From: Public Access DC Comments
Sent: 01 September 2017 17:17
To: Public Access DC Comments
Subject: Comments for Planning Application 17/01466/F

Address: Heyford Park Parcel B2A Camp Road Upper Heyford
Proposal: Addition of approximately 310m of metal 'field' style railings painted black (Retrospective)
Case Officer: Lewis Bankes-Hughes

From: Tim Screen
Sent: 25 August 2017 14:01
To: Lewis Bankes-Hughes
Subject: 17/01466/F - Heyford Park Parcel B2A Camp Road

DRAWN BY: MH	DATE: 19/12/14	DRAWING NO.: UPP2-02-300	REV: N
SCALE: 1:500 @ A1	CHECKED/DATE: B

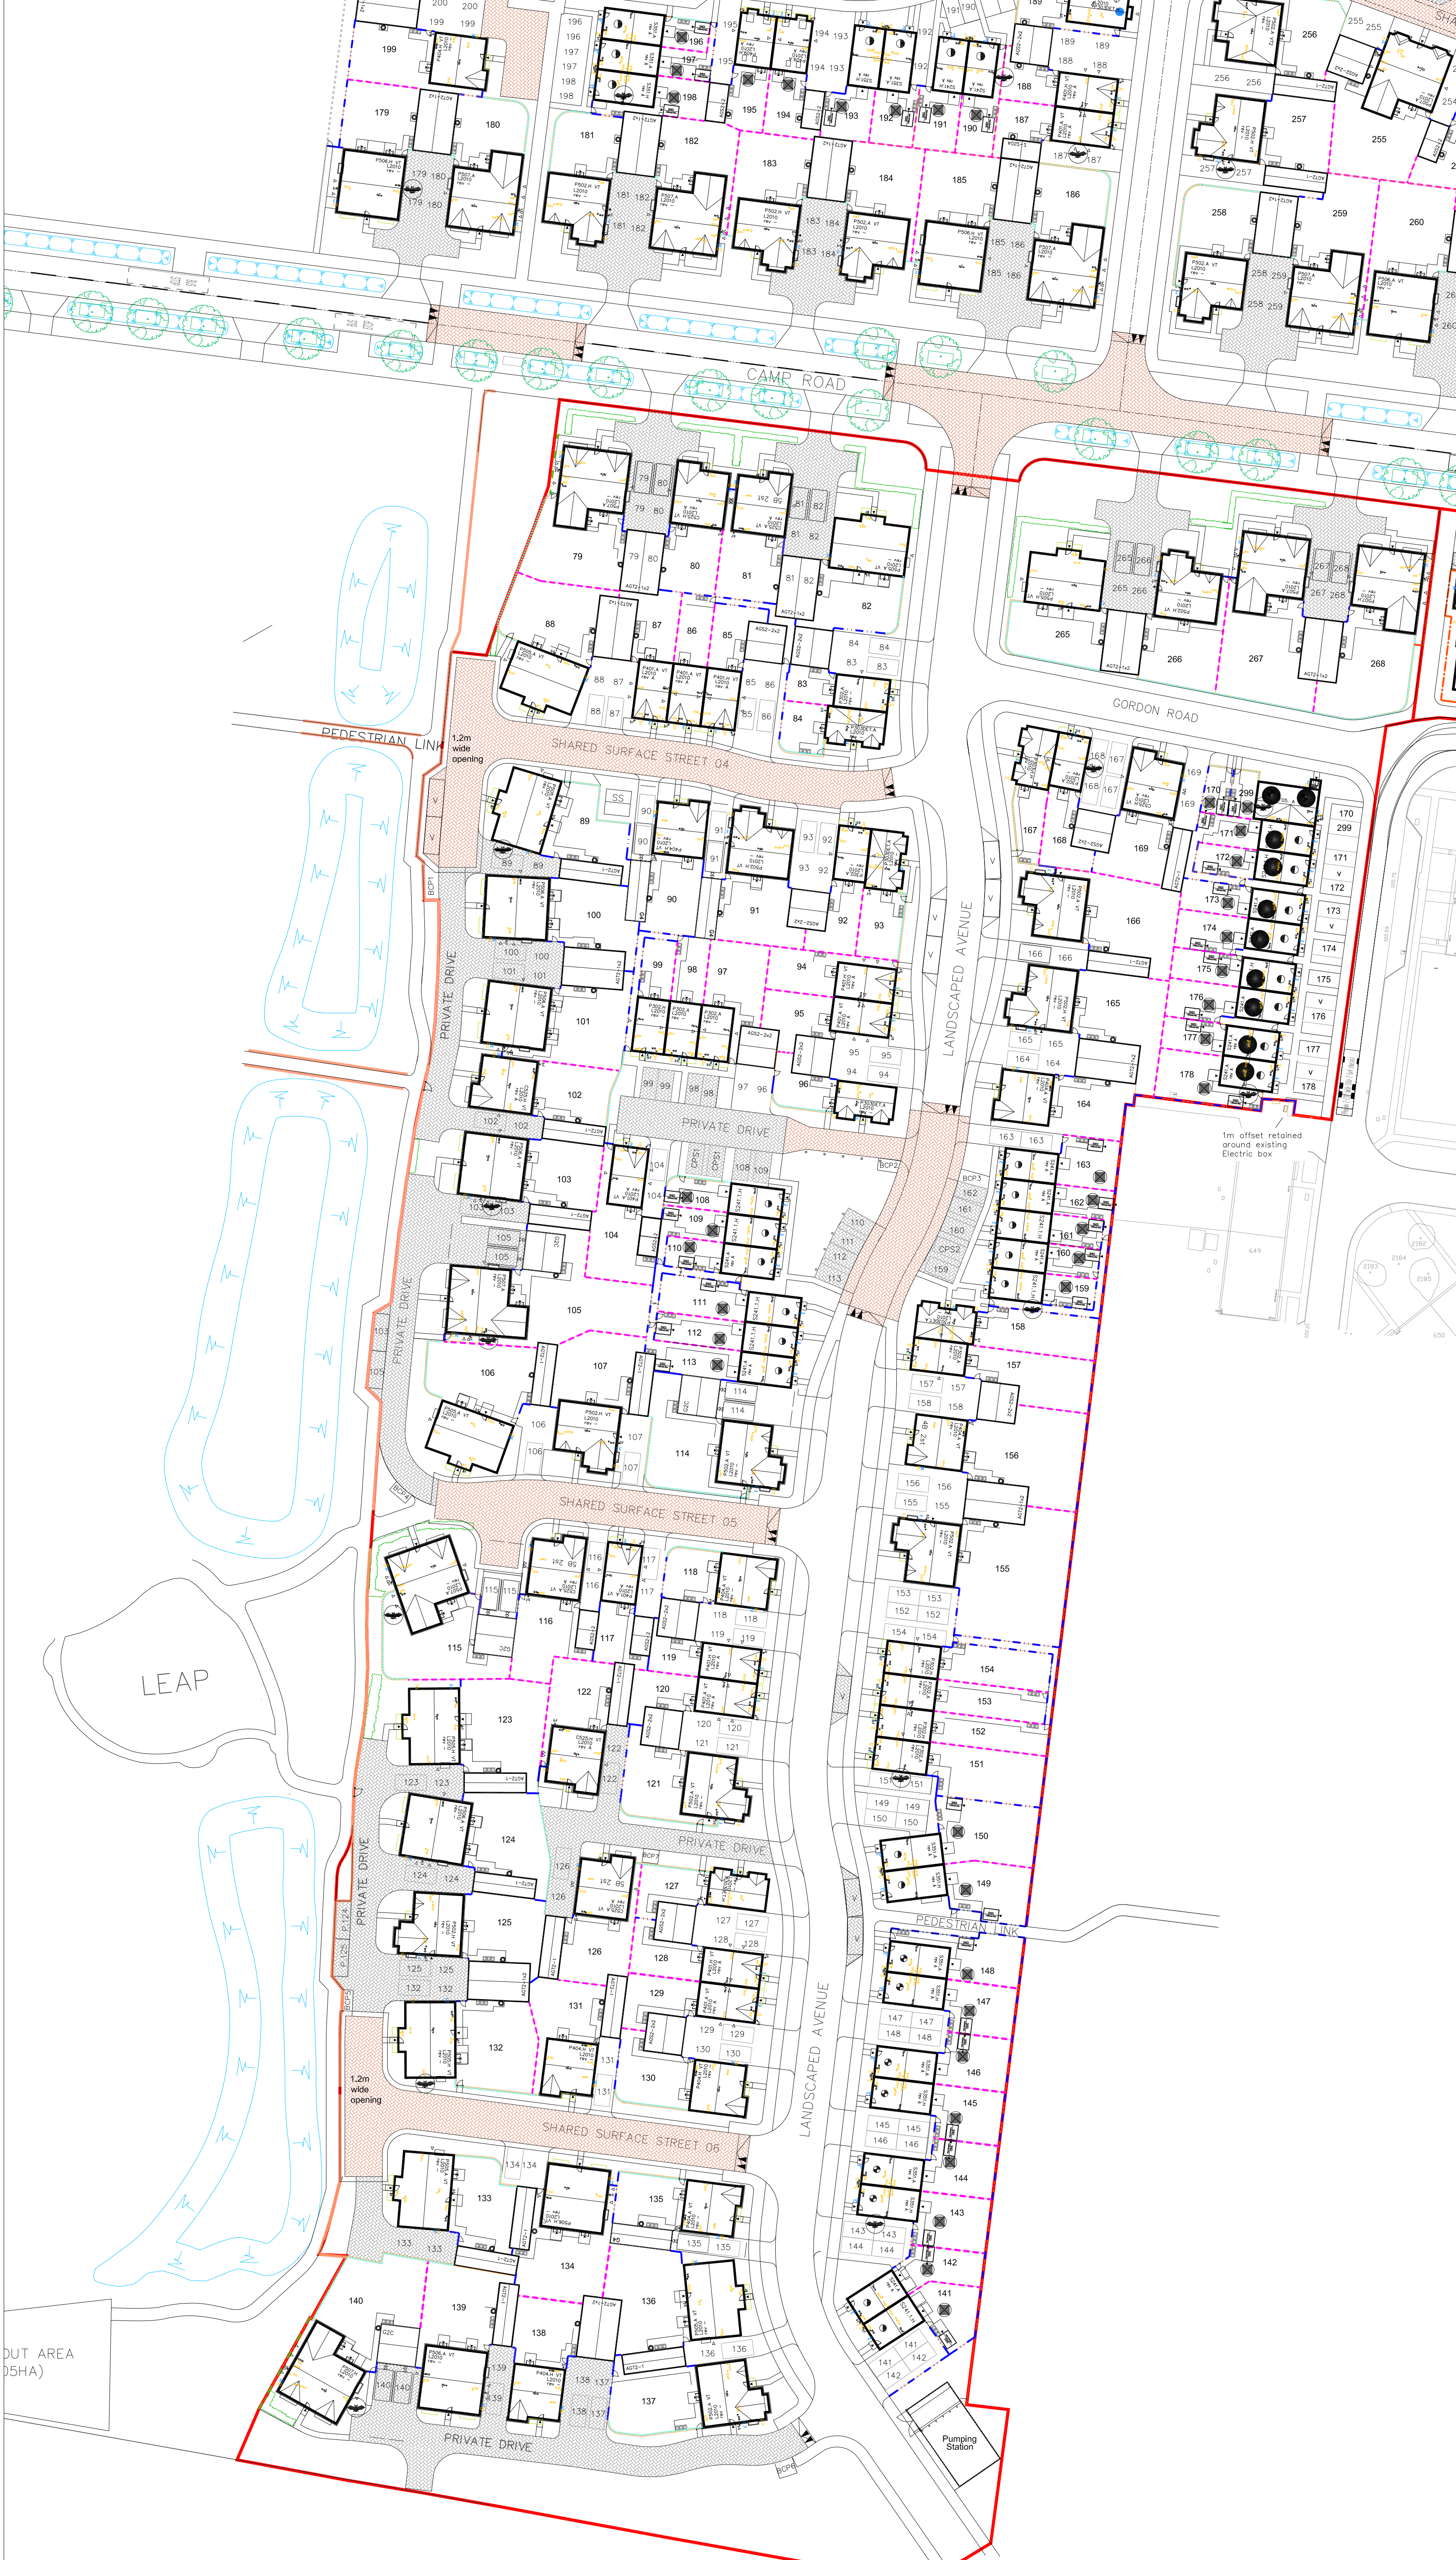
In consideration of the Fence Key Plan UPP2 -02-300.

I have no objections as long as 2 demountable bollards are installed, with padlocks, to the cycle path near plot 115, in order to prevent vehicle access. This should allow contractor and emergency vehicle access when required.
